28 February 2020

FUTURE
PLANNING AND DEVELOPMENT

Application under Section 73 of the Town and County Planning Act 1990 for variation of Condition 1 of A/81/18/RES at Quiet Waters, Roundstone Lane, Angmering, BN16 4AX

Plot 16 Section C-C

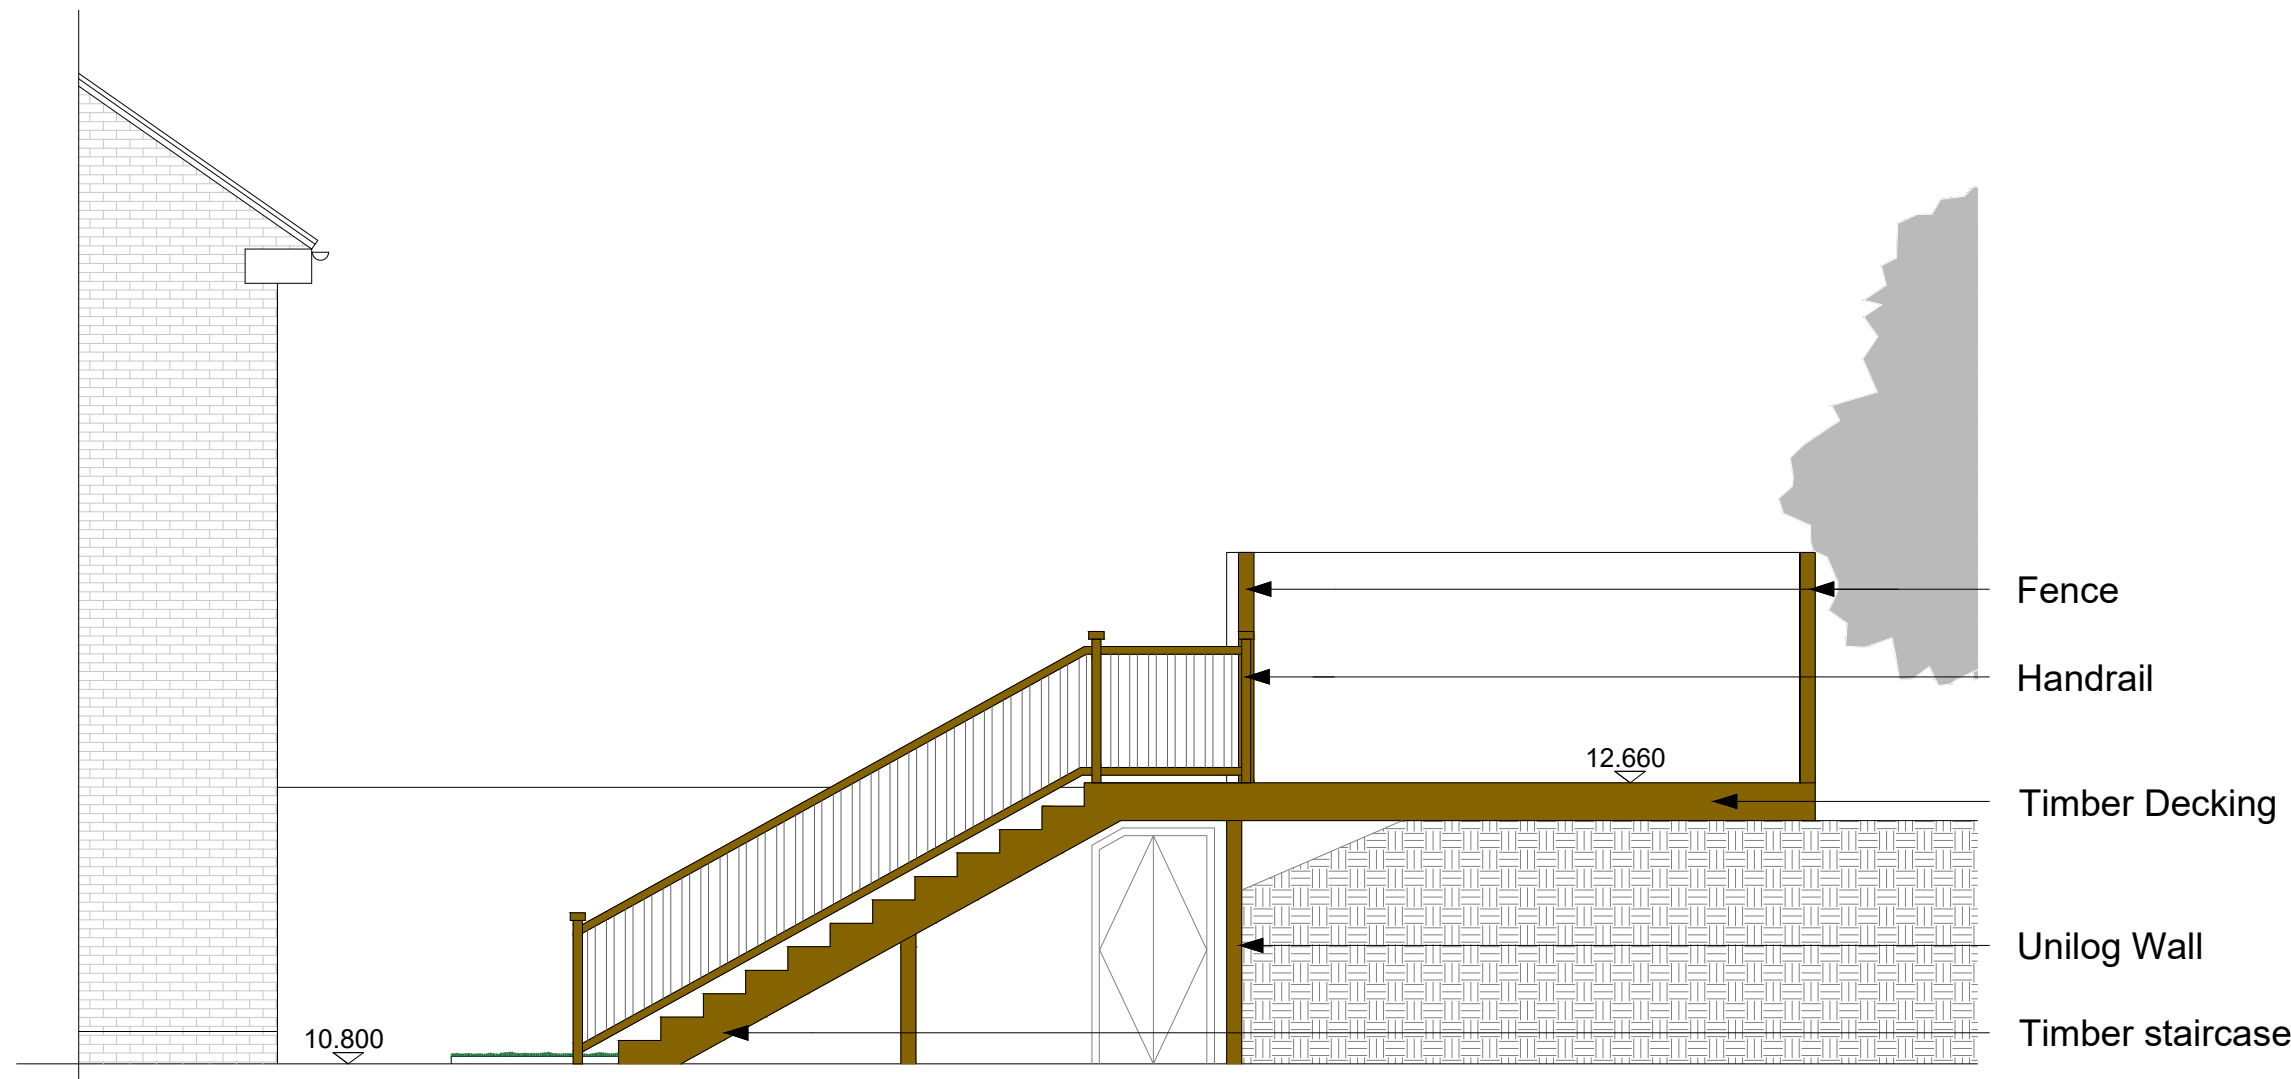
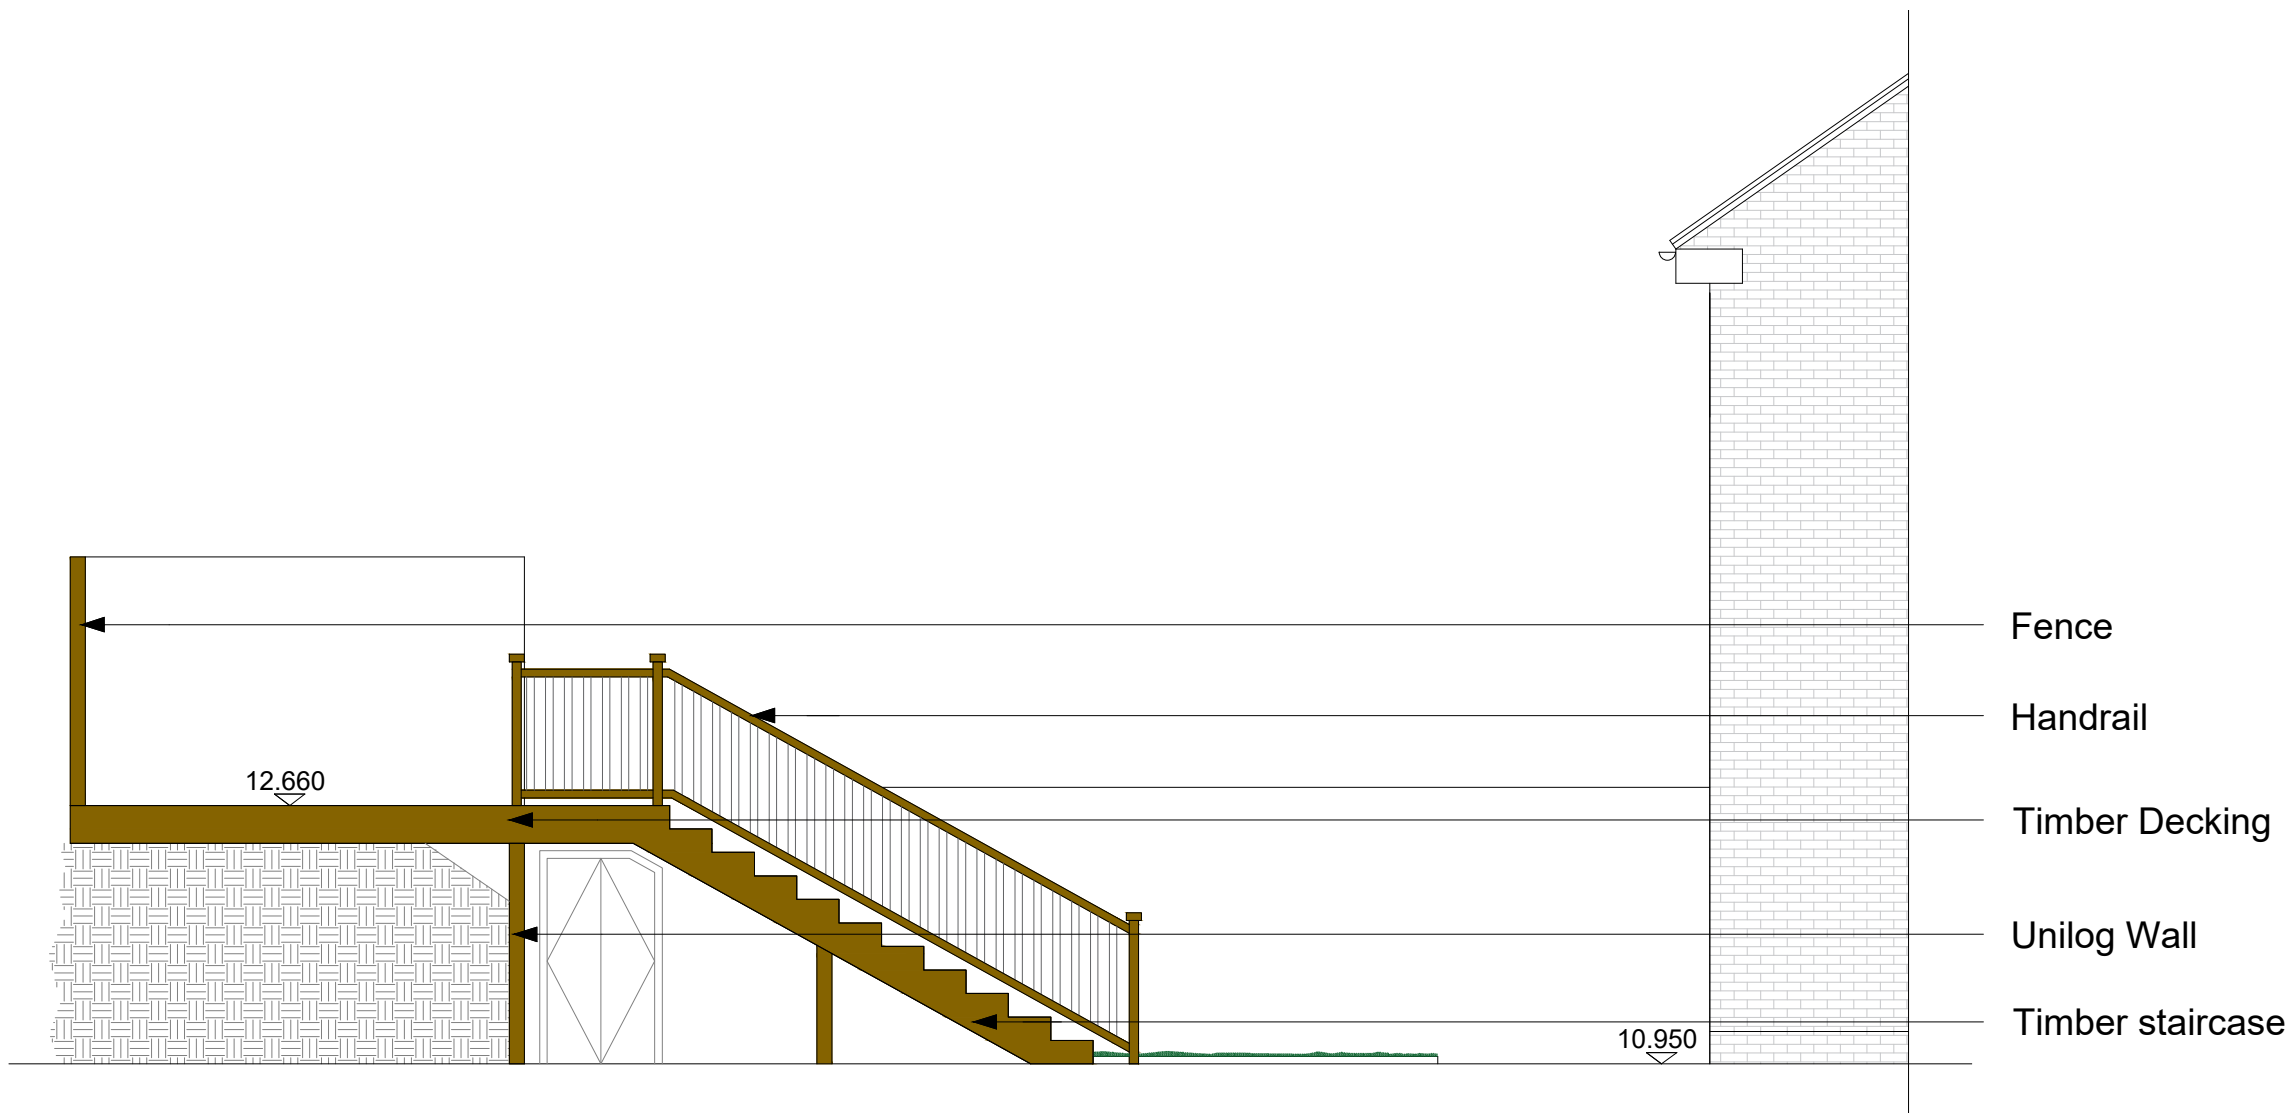
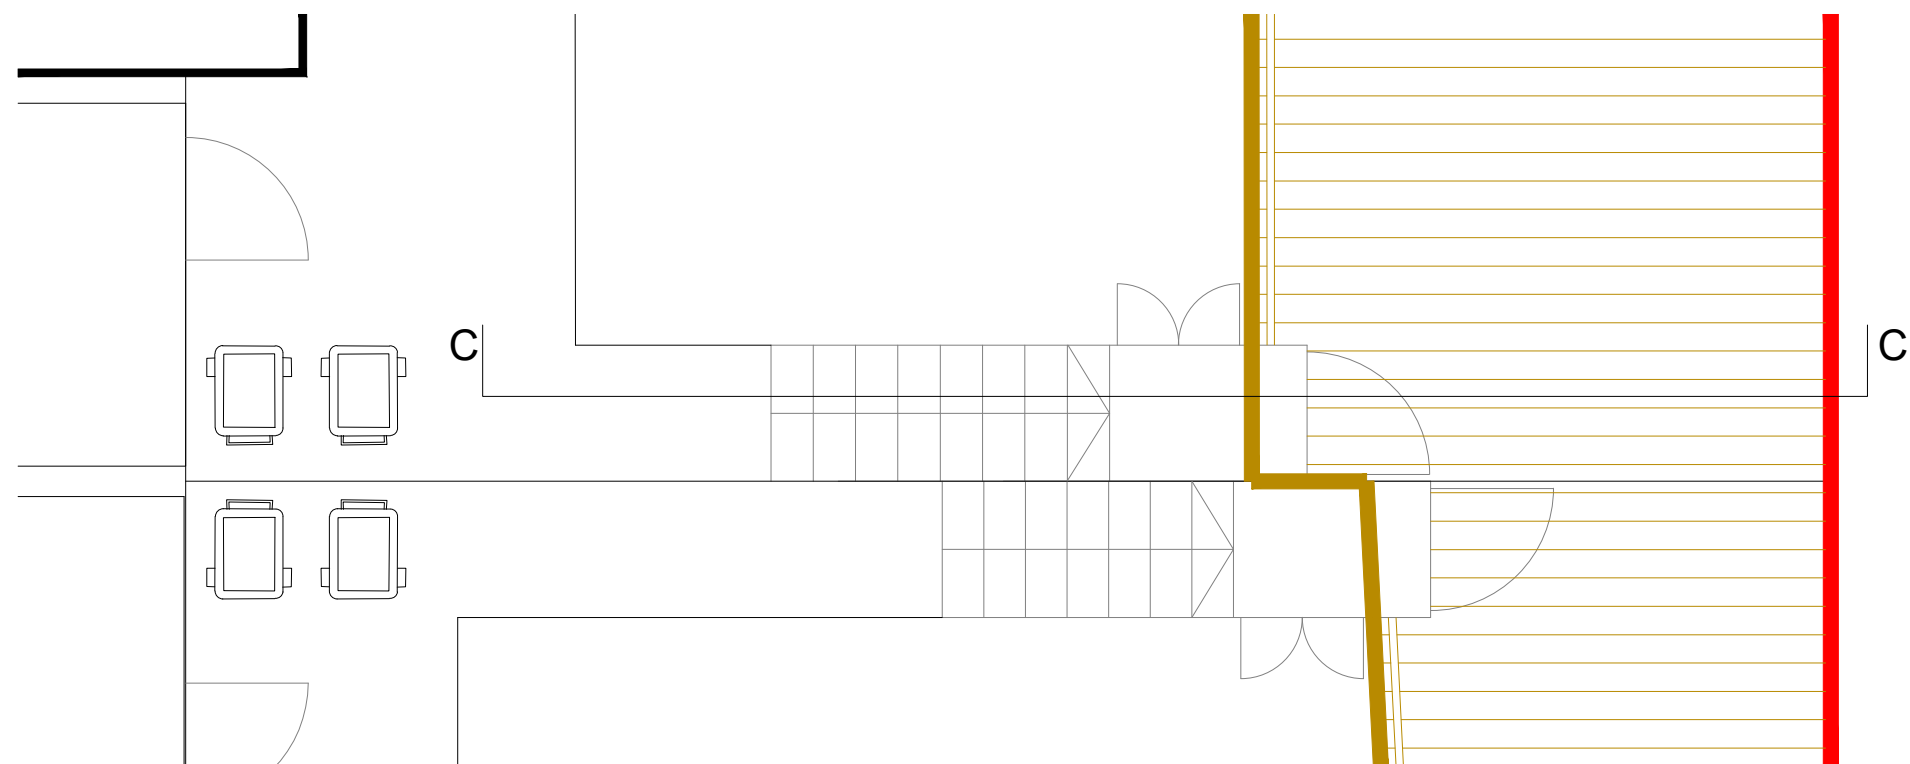
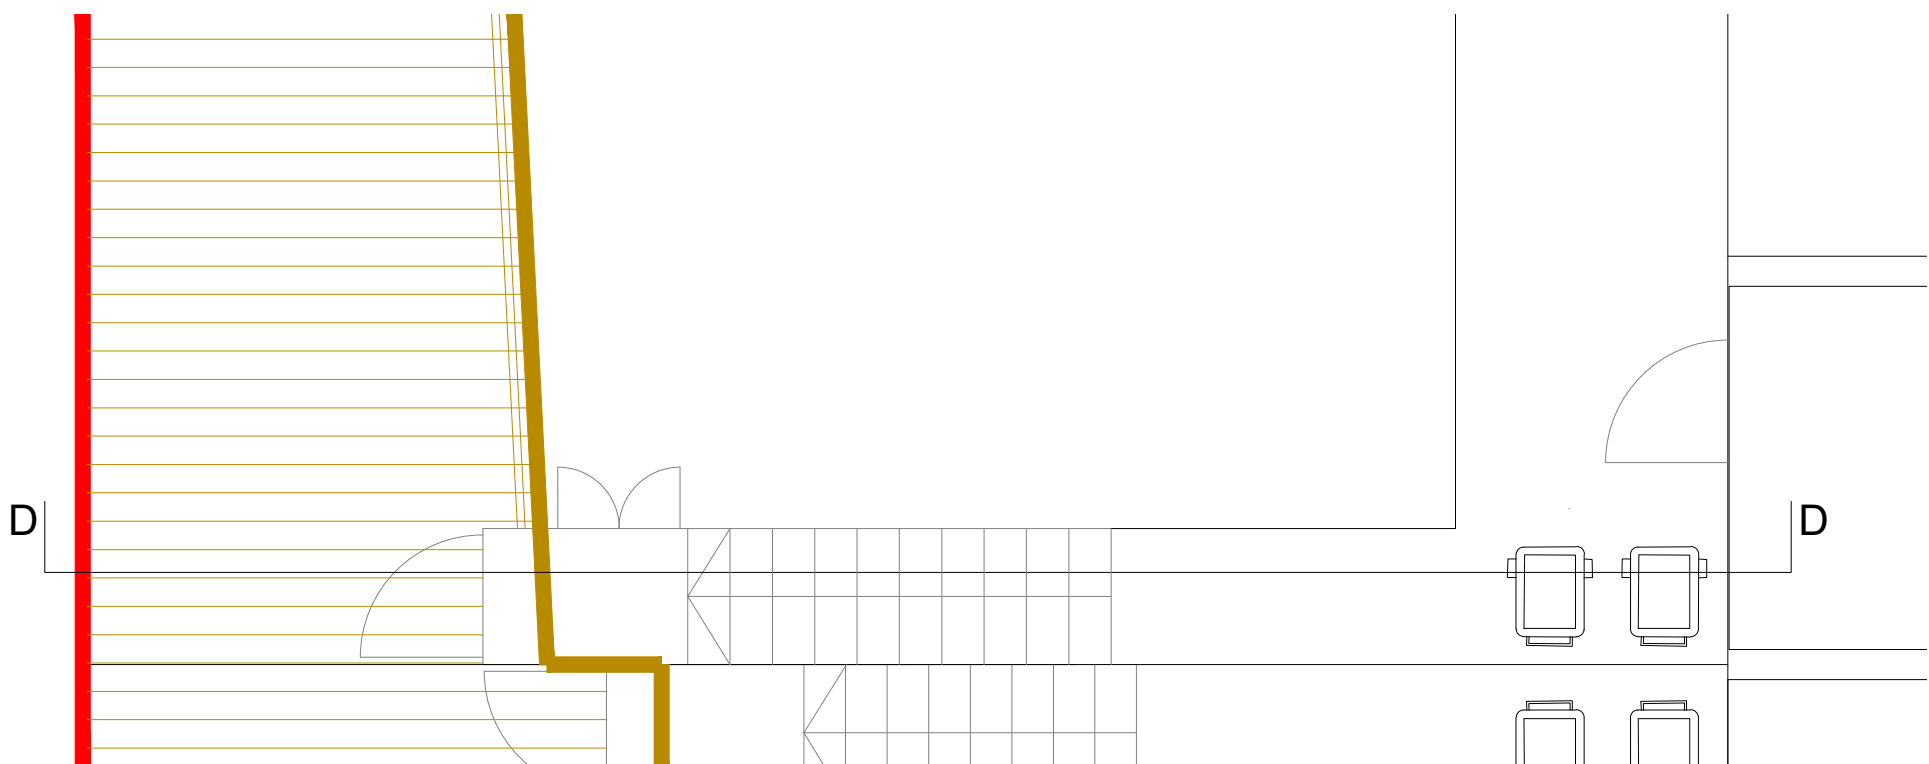
8. **Unilog Wall** – A handrail has been added along the top of the Unilog wall as a safety measure.
9. **Plots 15-18** – Wooden decking proposed to rear of gardens (behind Unilog wall) in order to make this area usable. Lightweight steps provided to the decked area with built-in storage underneath. Paths/patios extended to the position of the steps. Balustrades provided to match the decking style for Plots 15 and 18, with close-board fencing for Plots 16 and 17 to prevent overlooking.

However, the introduction of wooden decking to the rear of Plots 15-18 would constitute a material amendment to the scheme. This specific change is proposed in order to improve the quality of the external amenity space for these units. The approved scheme shows split level gardens, with a lower level at the back of the houses and a higher level behind a Unilog wall, accessed by steps up from the lower level. The rear part of the garden is not level and undulates quite significantly in some parts of the site, limiting its value as an amenity space for the houses. Existing sections through each garden are submitted, which illustrate the deficiencies of these areas as amenity spaces.

It is proposed to create a level area of decking for the rear part of the garden for each of the four plots, 15-18, thereby creating usable amenity space. Plans and sections of the proposed decking areas are shown on drawing 1006-Ang111 A. Given that the decking areas will be at a higher level than the rear gardens adjacent to the houses the proposals have been designed to secure privacy for the properties by reducing inter-visibility between windows and gardens – although the approved scheme already includes split level gardens. Specifically, either 1.8m or 1.5m close boarded fencing is proposed to separate gardens in order to reduce visibility and for Plots 16

and 17, which are semi-detached houses, where the potential for overlooking from the decking areas to the lower level rear gardens and rear windows is greater, 1.5m screens are proposed to prevent direct overlooking.
